Current Zoning: O-2(CD) LLWPA (office, conditional, Lower Lake Wylie Protected Area), NS LLWPA (neighborhood services, Lower Lake Wylie Protected Area)

Proposed Zoning: O-2(CD) LLWPA SPA (office, conditional, Lower Lake Wylie Protected Area, site plan amendment), NS LLWPA SPA (neighborhood services, Lower Lake Wylie Protected Area, site plan amendment)

Approximately 15.48 acres located along Steele Creek Road between Interstate 485 and Outlets Boulevard.

The petition proposes to amend a previously approved plan to allow an additional drive-thru lane, alter the O-2(CD) building envelopes, and change the zoning of a small parcel on the southern corner of the site from O-2(CD) to NS.

Sheet  
**RZ3.0**

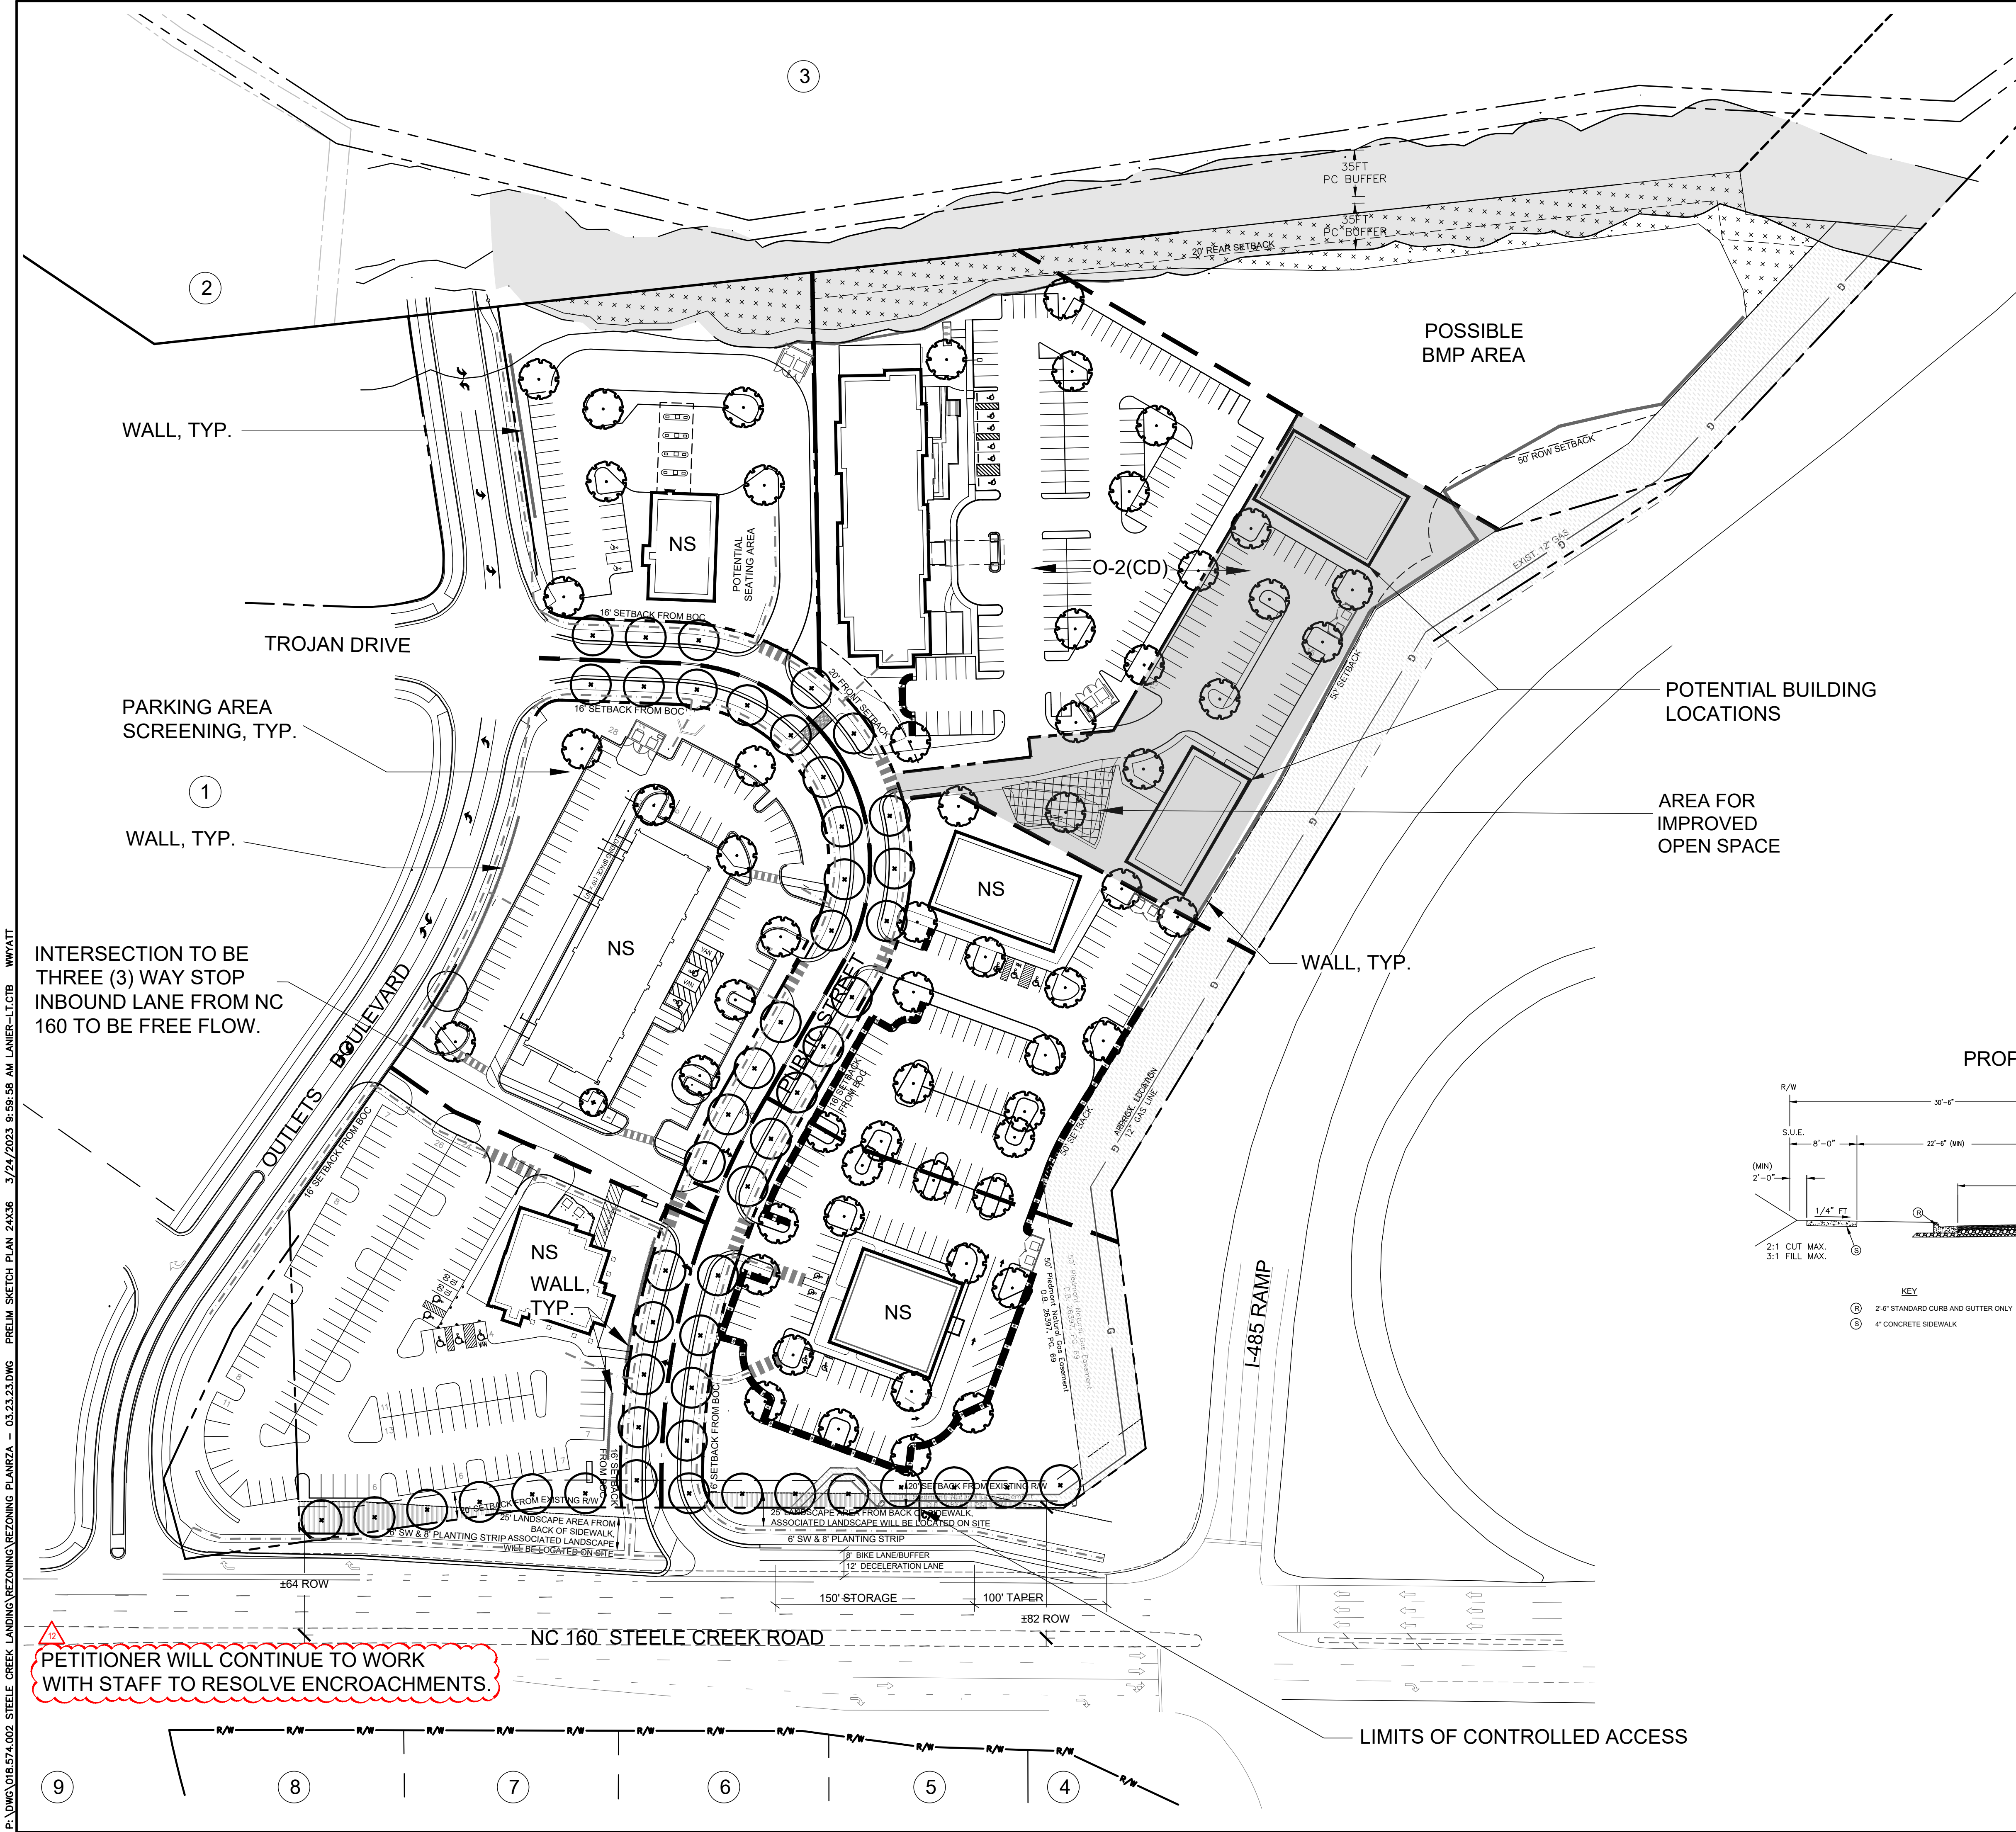
- 
3. ~~Edit conditional note 3.d to add "CDOT requests rights-of-way set at 2' behind back of sidewalk where feasible".~~ Revise site plan to show proposed right-of-way 2ft at back of curb on Steele Creek Road or 2ft behind the required sidewalk. If sidewalk is located outside of right-of-way provide sue. **OUTSTANDING**
  4. Revise site plan and add conditional note to install curb and gutter along the Steele Creek frontage between Outlets Boulevard and Trojan Drive. **OUTSTANDING**

5. Label the width of all potential stream buffers on rezoning plan, including the Undisturbed Watershed Protection Buffer for the Lower Lake Wylie Protected Area. Depending on project density, the Undisturbed Watershed Buffer can vary from 40' to 100' and should be labeled as such on the rezoning plan. **OUTSTANDING**
6. Verify that tree save area matches approved plans. **OUTSTANDING**
